From: simon-binns [REDACTED]
Sent: 06 March 2017 16:01
To: Simon Davis; [REDACTED]
Cc: Mike Wigmore
Subject: BE/180/16/PL North Bersted Street, Bognor Regis - Highways

Please see the below responses to the comments (28/2/17) received from Highways and attached revised drawings.

SITE PLAN
SCALE 1:200

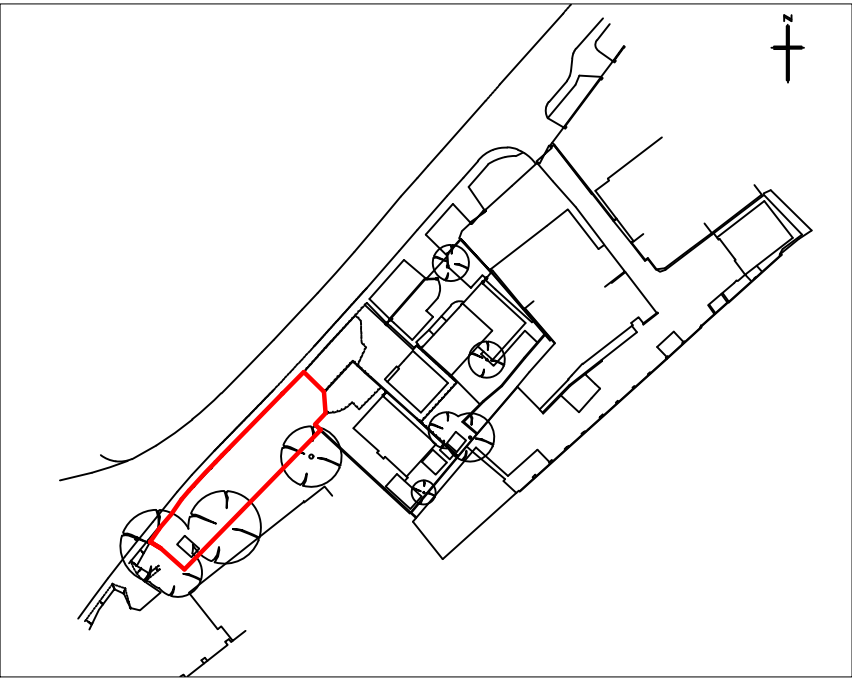
Existing Parking

The existing parking arrangements for the adjacent property No 2 is a garage is situated to the south of the property connected to the highway by a concrete driveway. Currently there is limited provision to turn on site, this will be improved with the removal of the splayed wall to the front. It is not proposed to install a gate from the highway or between properties, the line on the drawing was just an indication where a new surface would be constructed.

Date	Feb 2017	Drawn by	scb
Scales	@ A1	Status	PLANNING
Job No	TSP 573	Dwg No	PL-10
		Revision	B

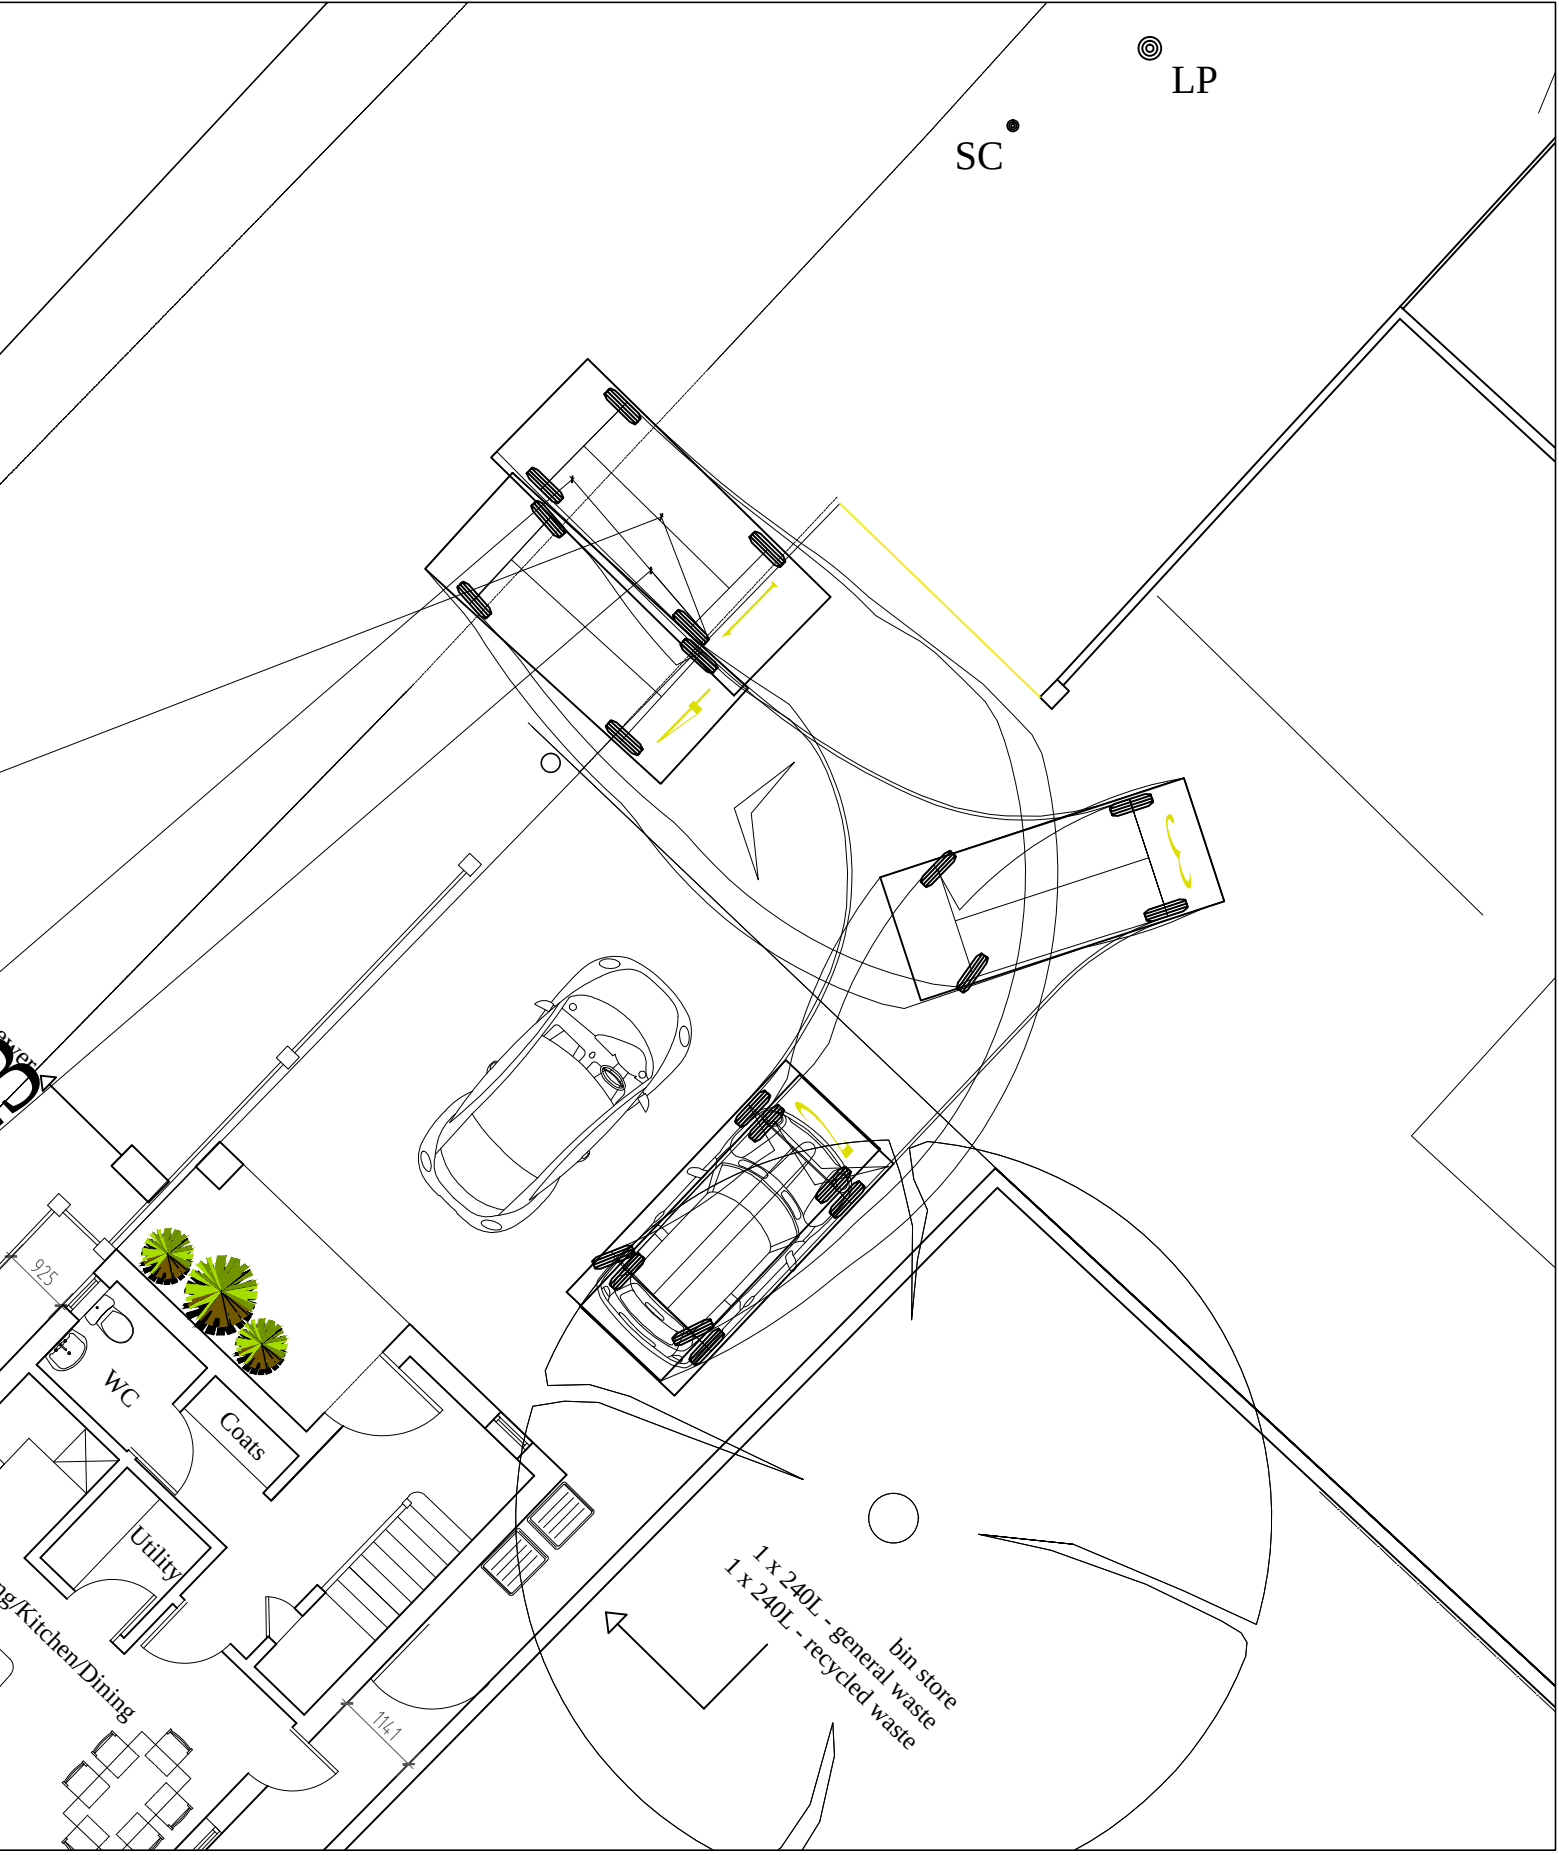
Turning

Sight Lines

Proposed parking turning head uses a standard swept path analysis has been modified to a larger 4.5m car as requested.

The fencing facing the highway was positioned into the site by 900mm for the length of the parking court to the corner of the proposed dwelling. The resultant strip of land will be hard surfaced and maintained by the applicant. We have positioned the sight lines 2.4m back from the highway in the centre of the private drive as indicated on PL10B. As well as 70m distance, the visibility splay bisects the edge of the carriageway 24.6m to the south. This is an improvement on the current existing highway access which has served No2 and much better than the previous gated entrance from the site which served commercial vehicles.
